**Final Acceptance Punchlist**  
**El Paso County – Department of Public Works - Stormwater Section**

Project Name:	Falcon Landing
EDARP Filing Number(s):	PPR1853, CON1915
ESQCP Number:	ESQ1915
Attendees:	DPW SW: Joshua Augustenborg, Ben Jones, Erica Rylander, and Glenn Reese DPW Development Services: None Developer: None
Date of Walk-Thru:	12/18/2023
Walk-Thru Number:	1

PROJECT: BECKETT AT WOODMEN HILLS LOT 3
SHEET TITLE: GRADING PLAN
FROM: n/a TO: n/a
JOB NO. 06-0056 SHEET 4 OF 9

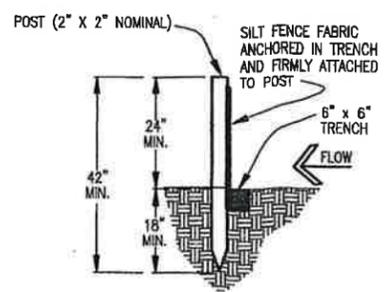
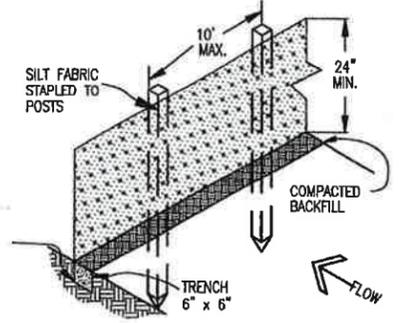
- The energy dissipation at the inflow point of the Porous Landscape Detention (PLD) pond was not installed. Rill erosion is now occurring. See Sheet 3 of Construction Drawings (CDs) for the detail with concrete rundown and river rock. Install energy dissipater per the detail (concrete rundown and river rock). Alternatives to this design may be proposed to the County for approval.
